PRE-APPLICATION ENQUIRY DC/21/00766

Watchmakers Cottage, Crowcroft Road, Wattisham, Ipswich Suffolk IP7 7JZ

Pre-application Enquiry

Rear extension to property

DRAWING
 Proposed Elevations

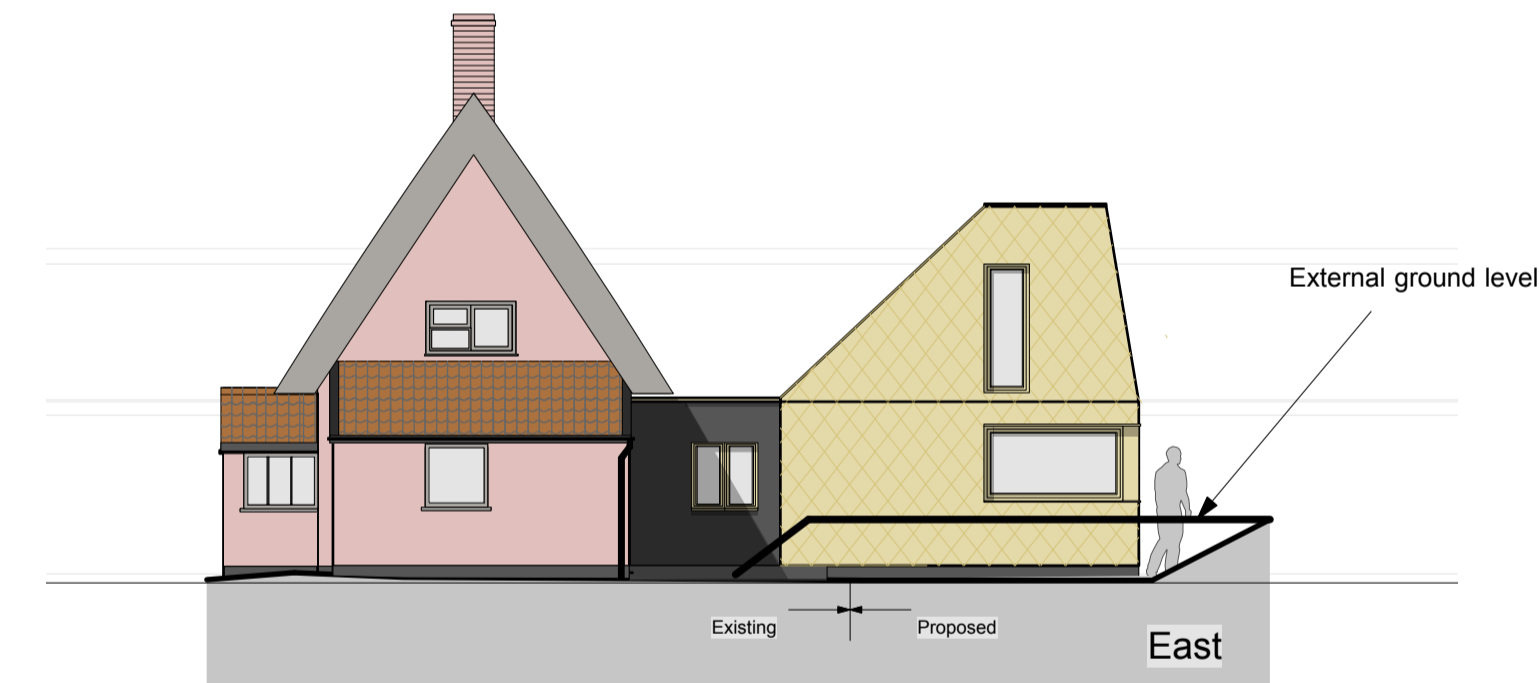
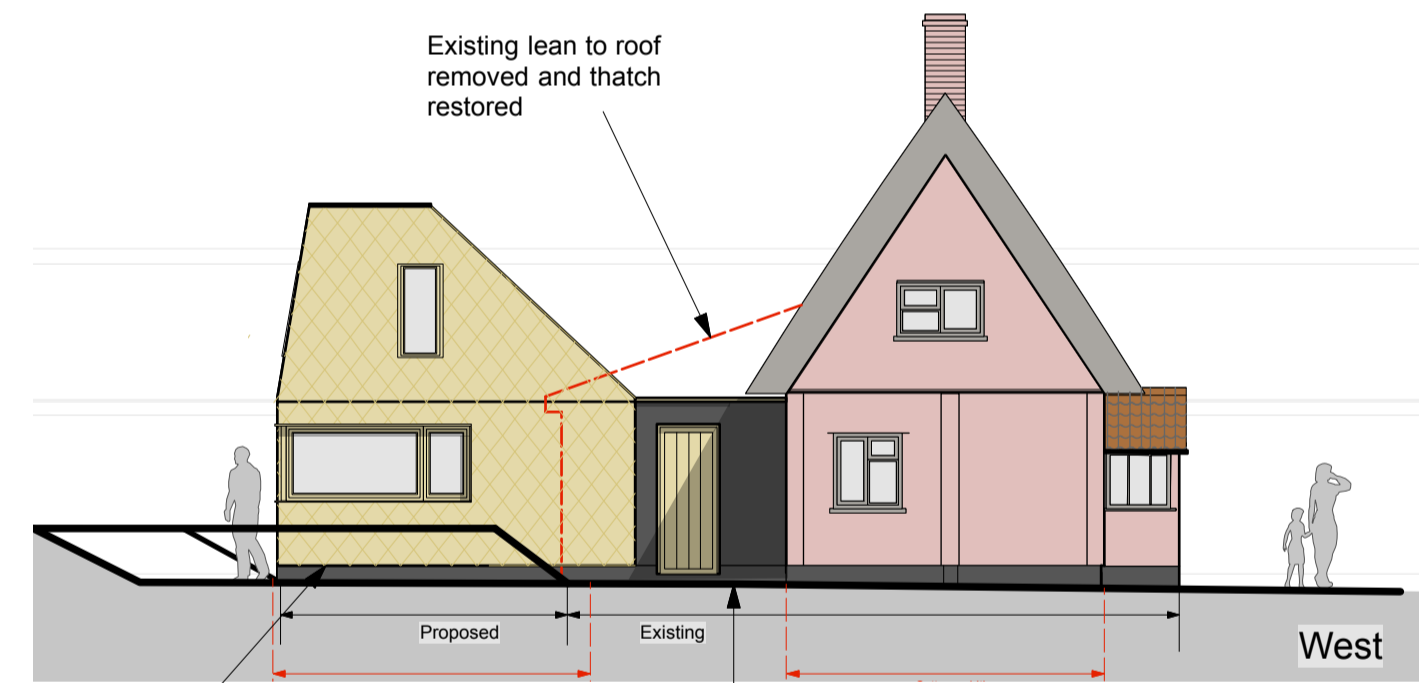
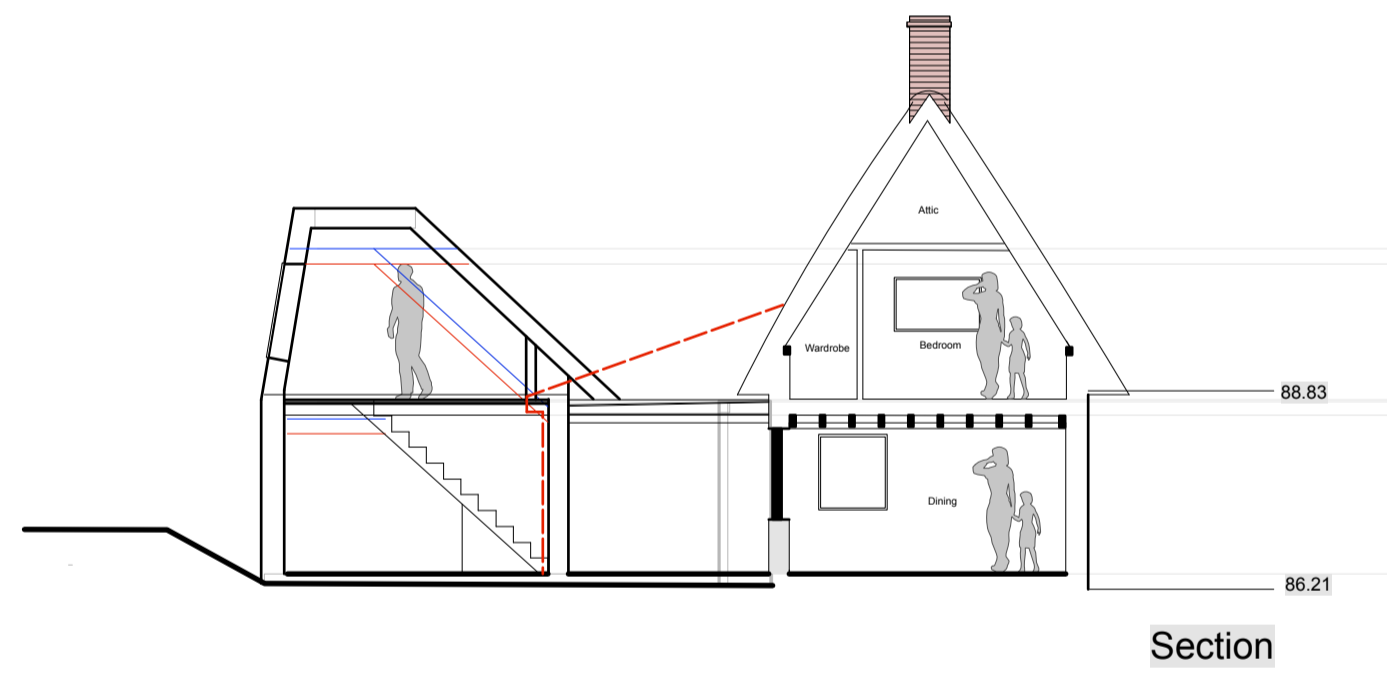
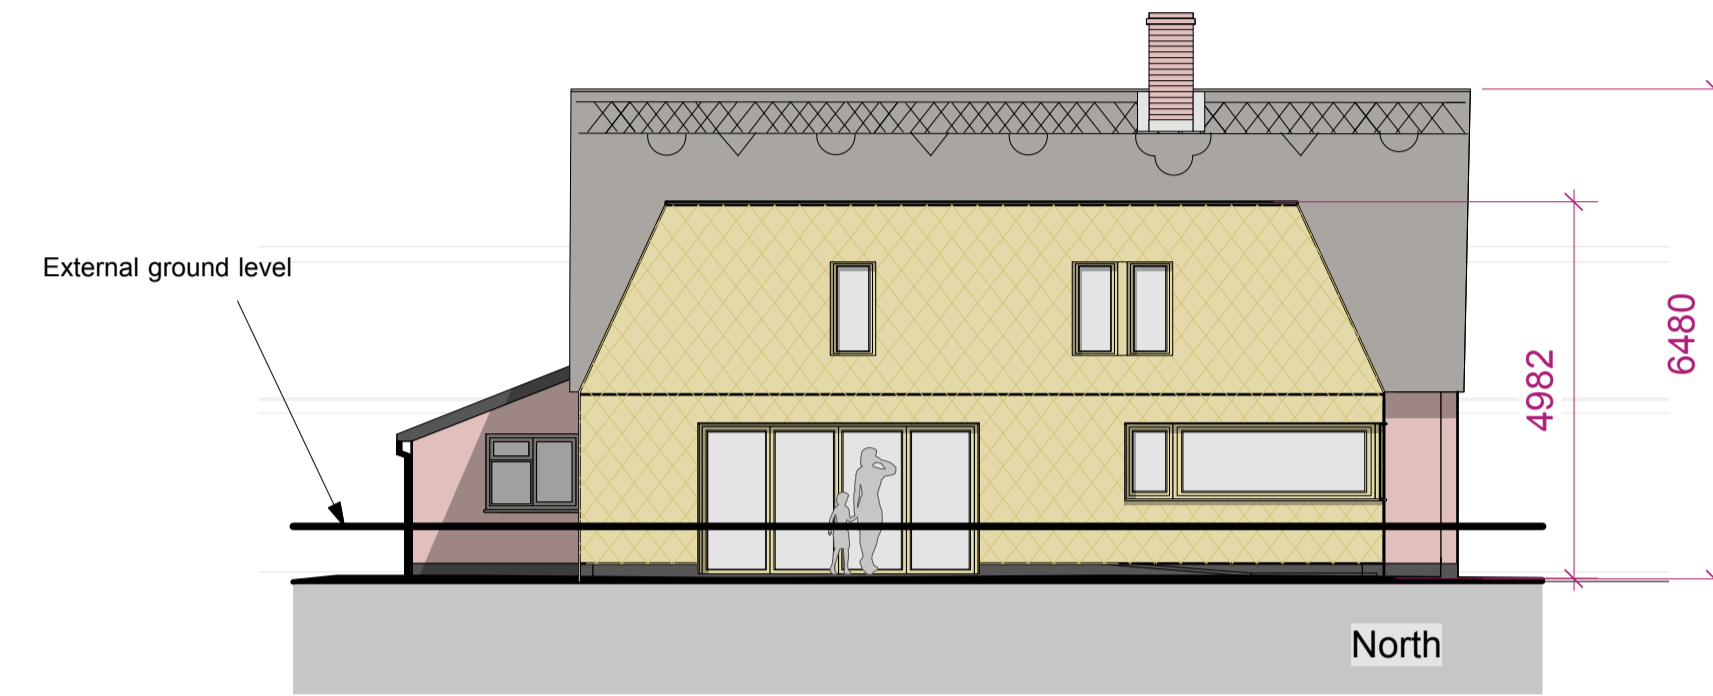
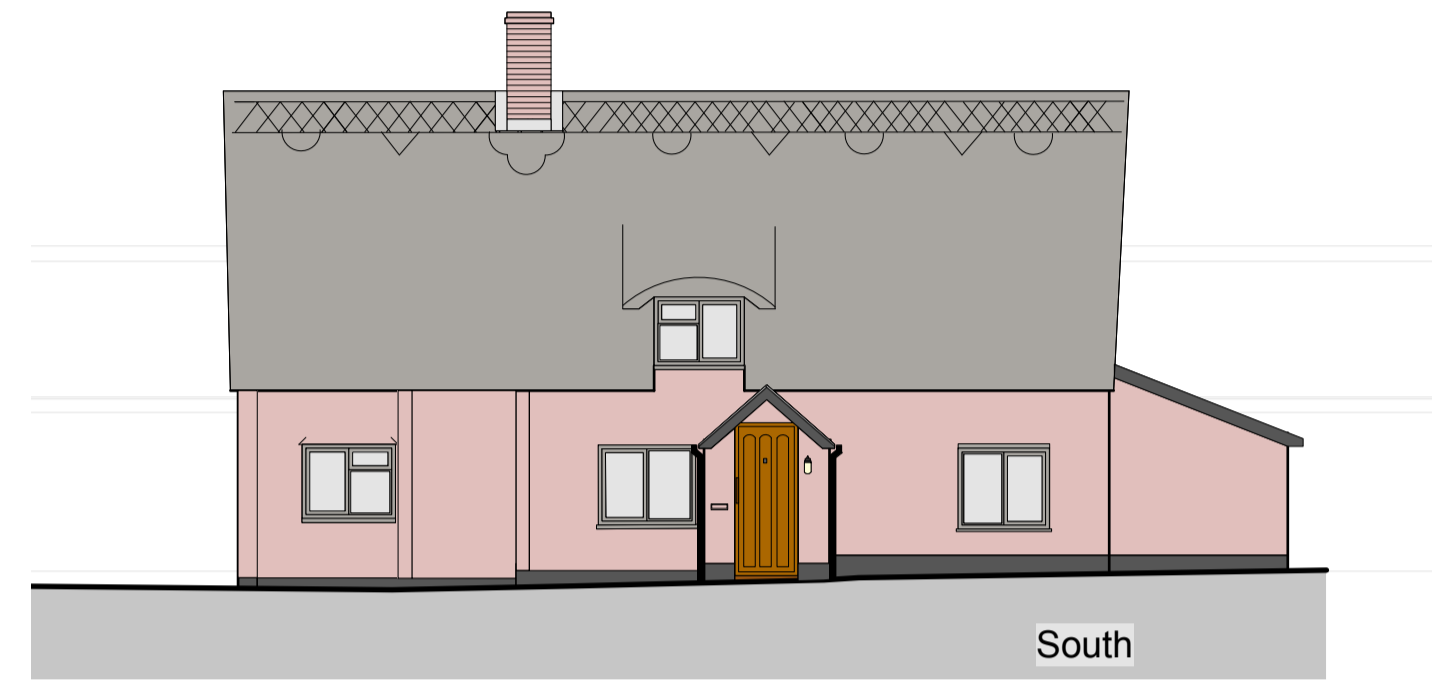
The approach to further extension is to enlarge the existing addition under a different roof-form. The footprint of the extension would be approximately double, and would be significantly larger than that of the original dwelling. The roof form would have a narrow linking area with a deep roof of asymmetrical pitches. Under the roof, much of the footprint of the existing extension would be retained with a similar but larger footprint beyond.

The scale of the resulting extension compared with the original dwelling gives cause for considerable concern. In particular, because of its roof form and its materials, the proposed extension would appear to have a deeper footprint than the original building, and would compete visually with it.

The scheme has some of the character of the 'linked-detached' approach, which can offer scope for extending small buildings while respecting their modest scale and historic integrity. In this instance the lean-to roof would be replaced by the roof of the proposed extension reaching over the existing, which would result in ambiguity between internal and external volumes. The ambiguity would also be apparent in the wall treatments with the flint extending across the existing extension. Losing the lean-to also reduces the visual weight of the existing building, with the existing lean-to transforming into a lean-to on the proposed extension. While this would allow better appreciation of the original building, and reinstatement of thatch, it would add visual weight to the proposed extension. In my view a better hierarchy and relationship would be achieved by retaining a lean-to element as existing, with any further addition attached beyond. In all, I am doubtful that a first floor can be incorporated without challenging the dominance of the original building.

I am not convinced that flint walling would be suitable for the proposed extension. This walling usually denotes a building of some social standing rather than an ancillary outbuilding or addition, and in this instance it would invert the existing relationship of the extension and the original host building. I am also doubtful that flint would appear satisfactory in the shallow areas of wall above the extension's windows.

Even in an extension in contemporary idiom I would not support a roof dormer / balcony feature. This feature would appear out of scale and give the addition a top-heavy appearance.

Concern is raised regarding the design of the proposed extension, and the roof form in particular. The roof form would have a narrow linking area with a deep roof of asymmetrical pitched which would not reflect the host dwelling. Please refer to the Heritage section below for further comments regarding design.
